Planning Application No: 3/2026/0496

Proposal: Proposed rear dormer and erection of a garden room.

Location: Casa Mia 8 Beasley Avenue Simonstone BB12 7HU

Tahira Akhtar BA (Hons)
Technician
Highway Development Control
Highways & Transport

Ground Floor Plan as Proposed

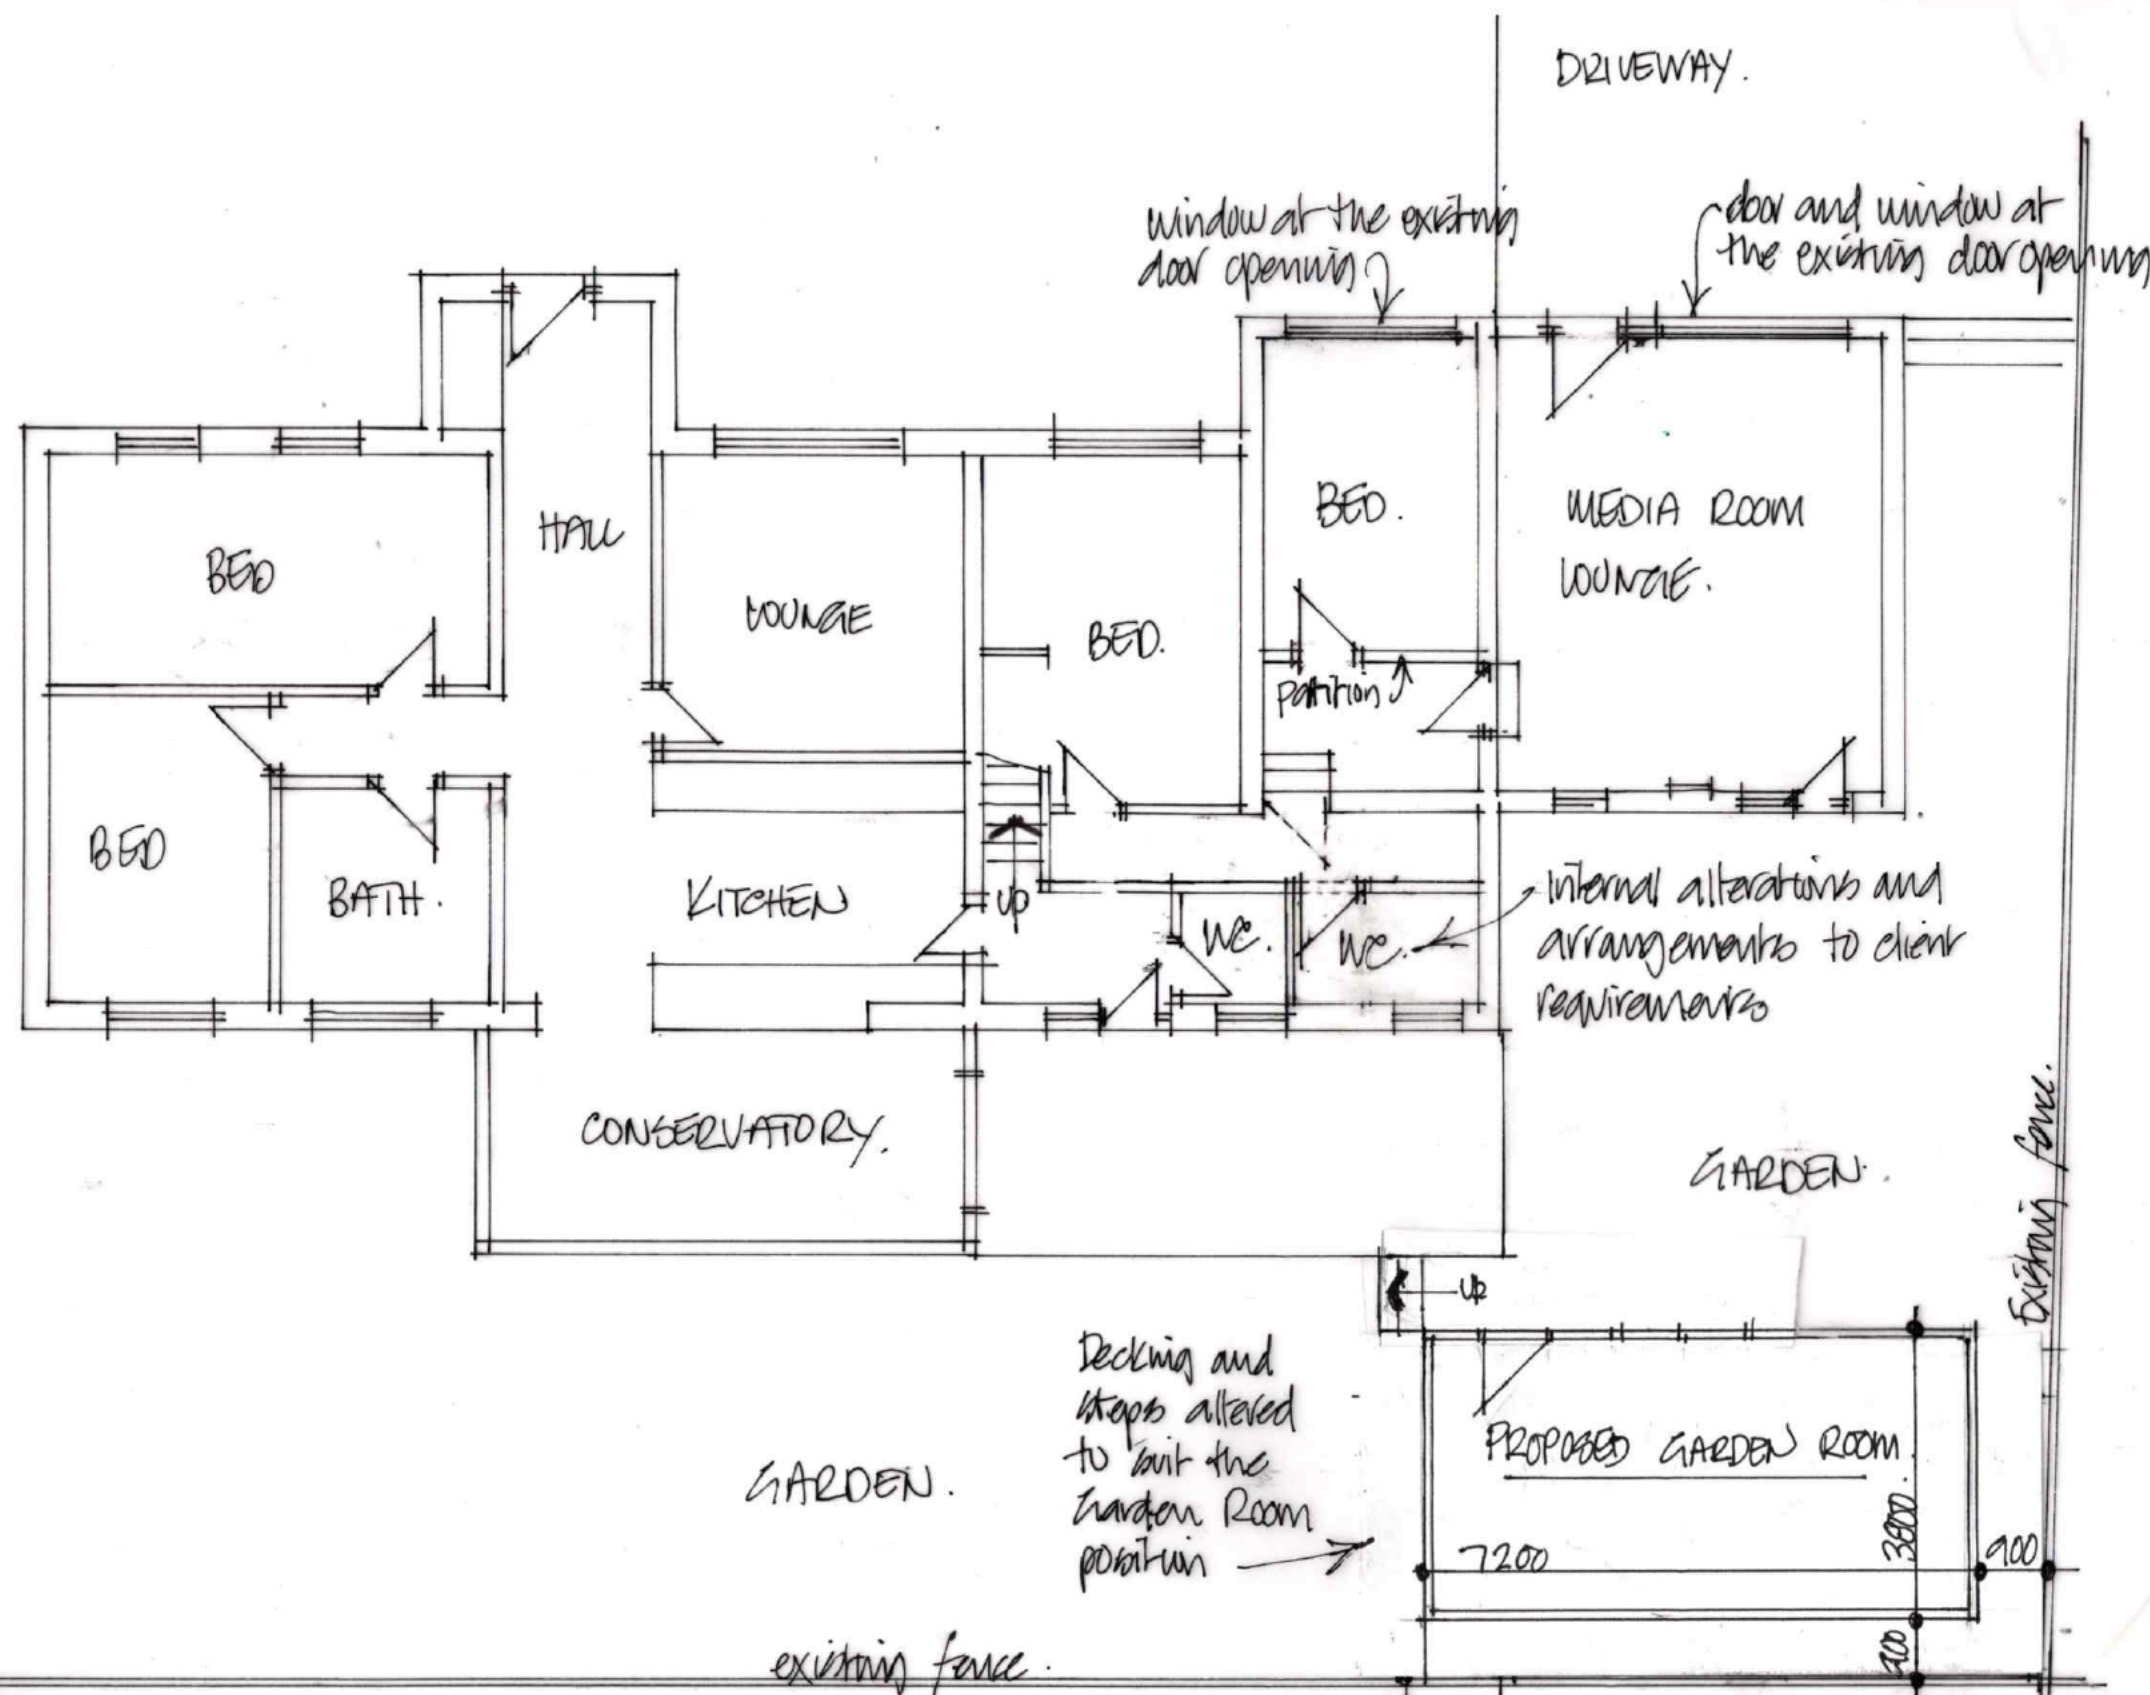
There is a loss of a garage with this proposal therefore a loss of a parking space. There is an increase in number of bedrooms from the existing 3 to a proposed 4. Parking standards require 3 parking spaces within the curtilage of the property for this size of proposal. A parking plan is required to demonstrate this. The spaces should each measure 4.8m in length and 2.4m in width, where a parking space is located adjacent to a fence or similar obstruction, an additional width of 0.6m is required to facilitate access to the vehicle. The area adjacent to the parking space would also be used for pedestrian access associated with the dwelling, as such, a further 0.2m is required.

Secure provision should be provided within the dwelling for cycles. As there are 4 bedrooms, therefore, 4 cycle spaces are required. Reason: To ensure the provision and availability of adequate cycle parking and the promotion of sustainable forms of transport. The cycle spaces should be covered and secure.
